**From:** Pagham Parish Council [REDACTED]  
**Sent:** 05 October 2015 14:23  
**To:** Planning.Responses  
**Subject:** Pagham planning responses

P/86/15/PL 11 Abbotsbury Pagham PO21 4RX - 1 No. 2 bedroom semi-detached bungalow – further comments as advised on 30<sup>th</sup> September 2015.

P/15/58.2 – 11 Abbotsbury, Pagham PO21 4RX – 1 No. 2 Bedroom semi-detached bungalow.

Proposed Floor Plan & Site Plan

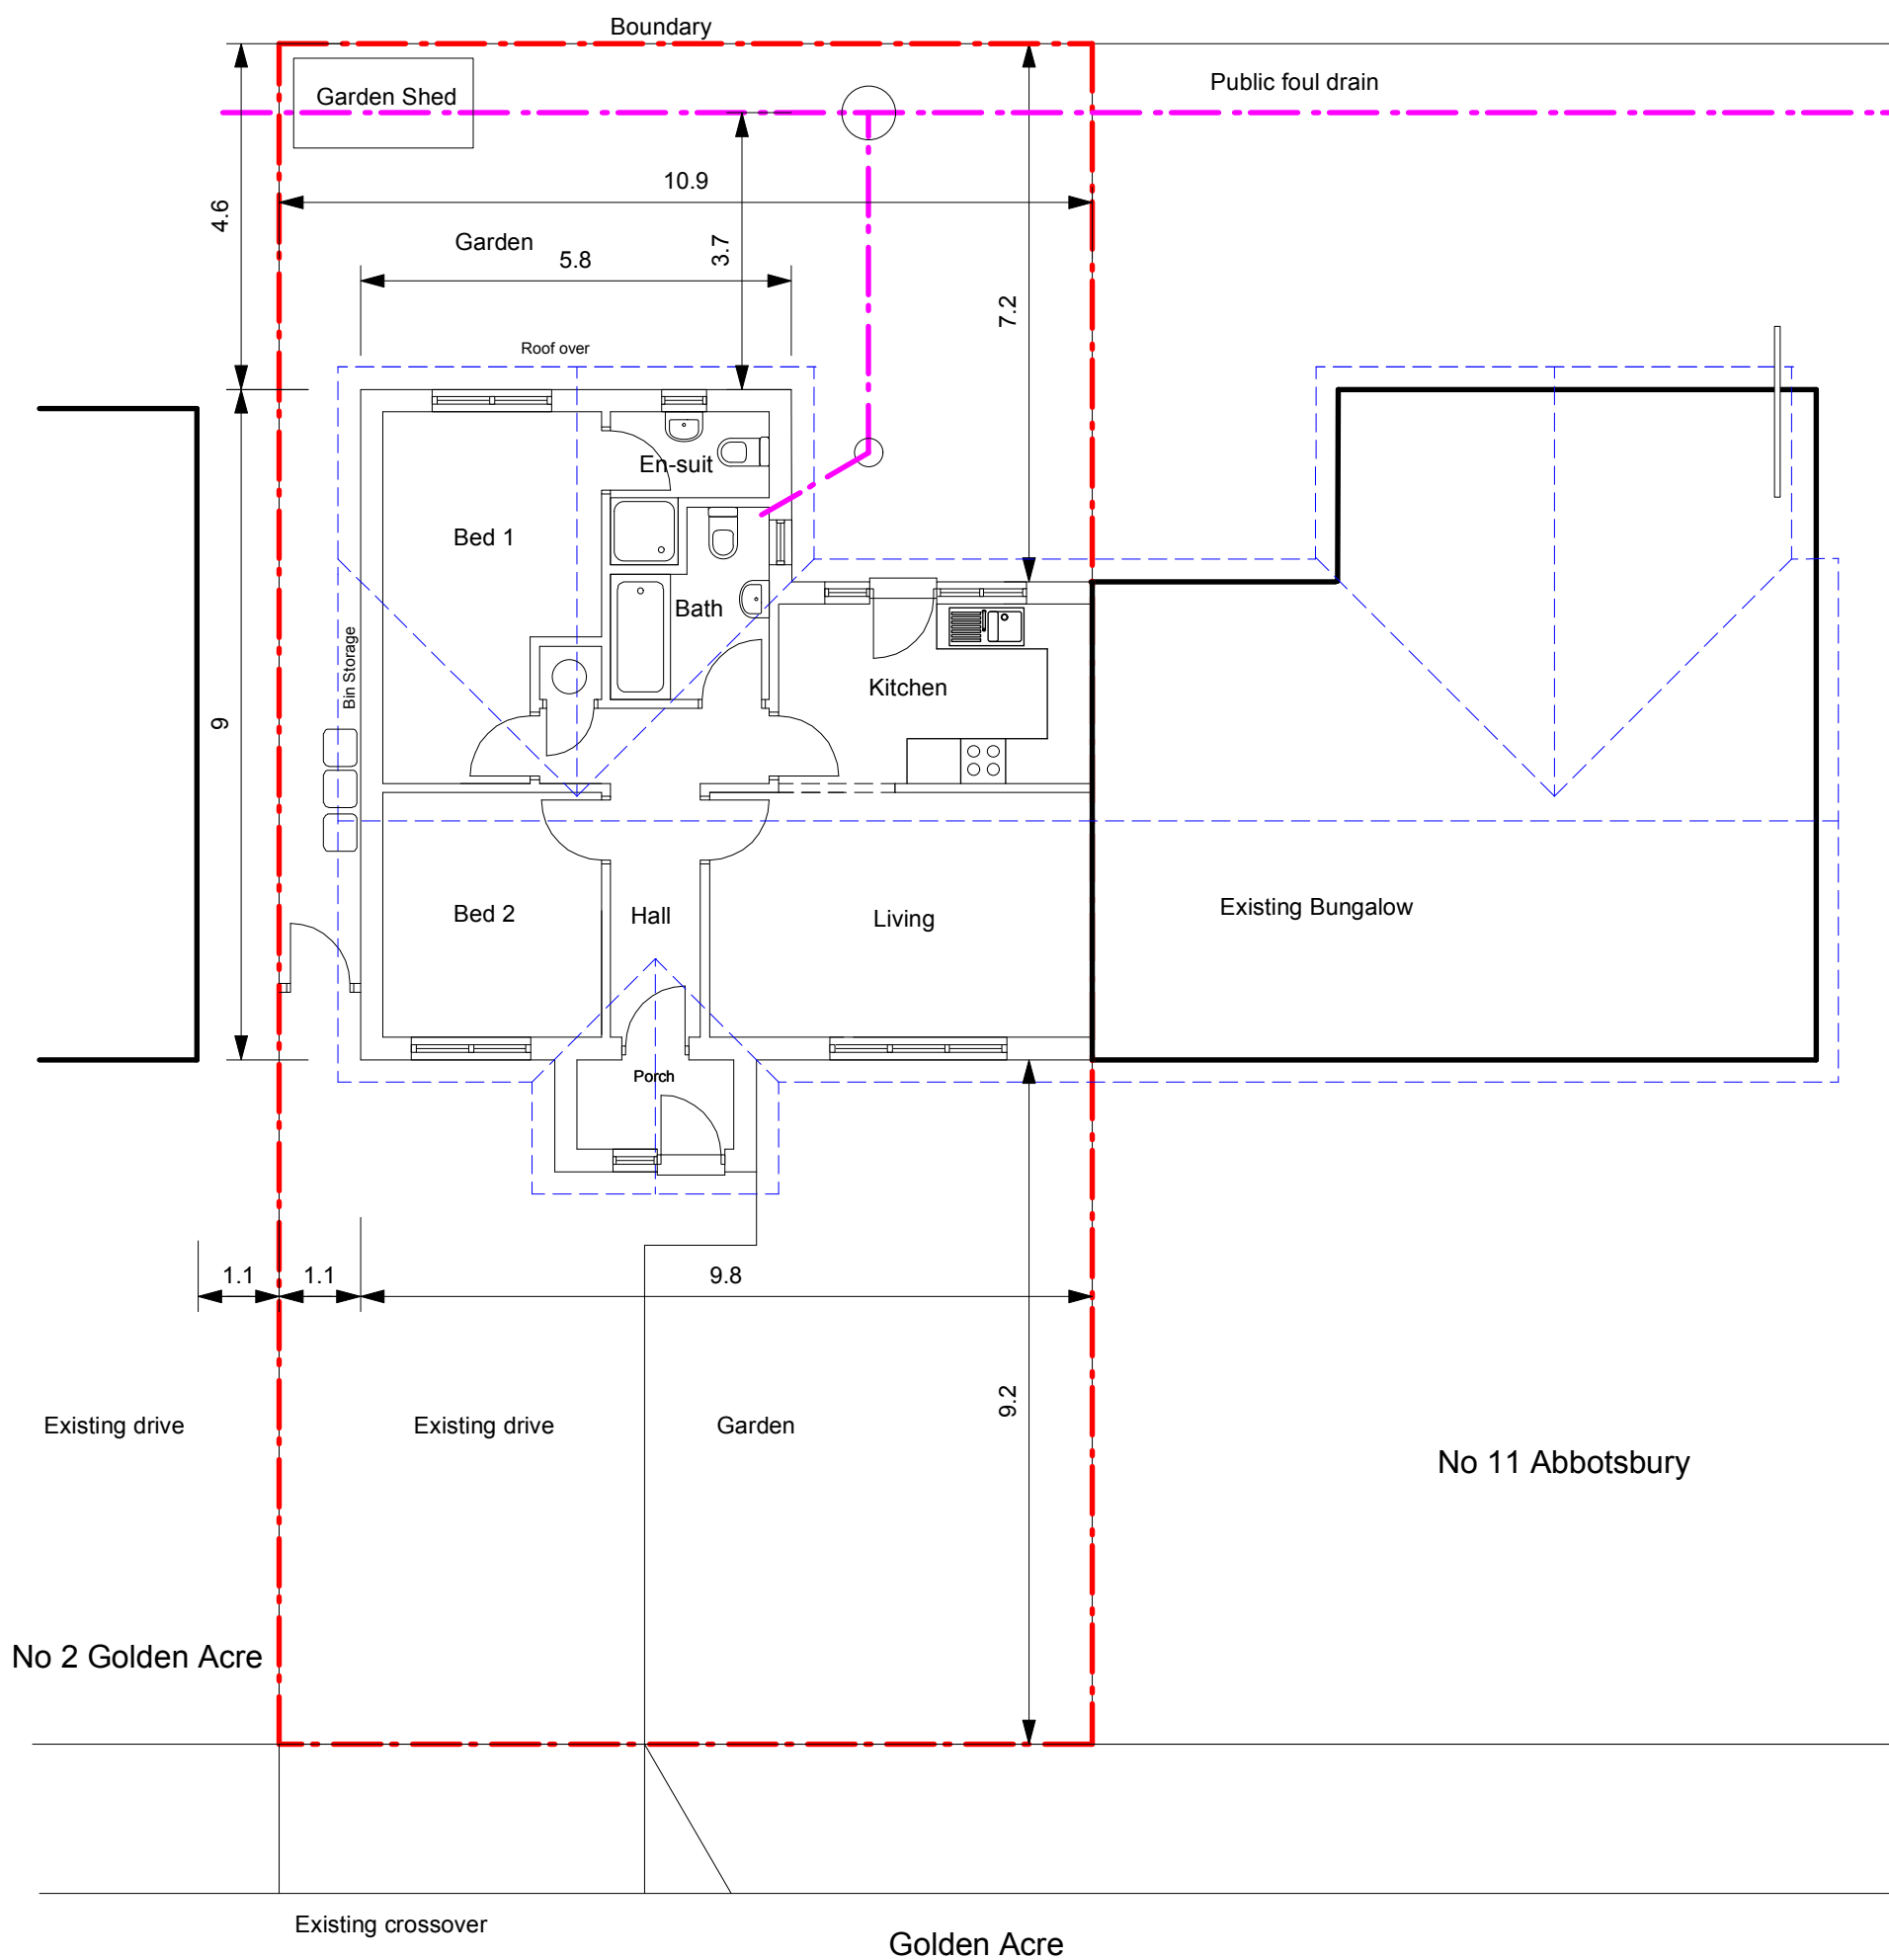
*It was felt, nevertheless, that the proposals for a conjoined dwelling to the existing bungalow could be viewed as cramped and out of character with the existing spatial context and streetscape. Of most concern was the very limited space accorded to the rear garden amenity area, which is out of character with the spatial context of the area. There will also be a similar deficiency in garage space, an existing facility having been deleted, and no such provision included to serve the proposed new dwelling.*
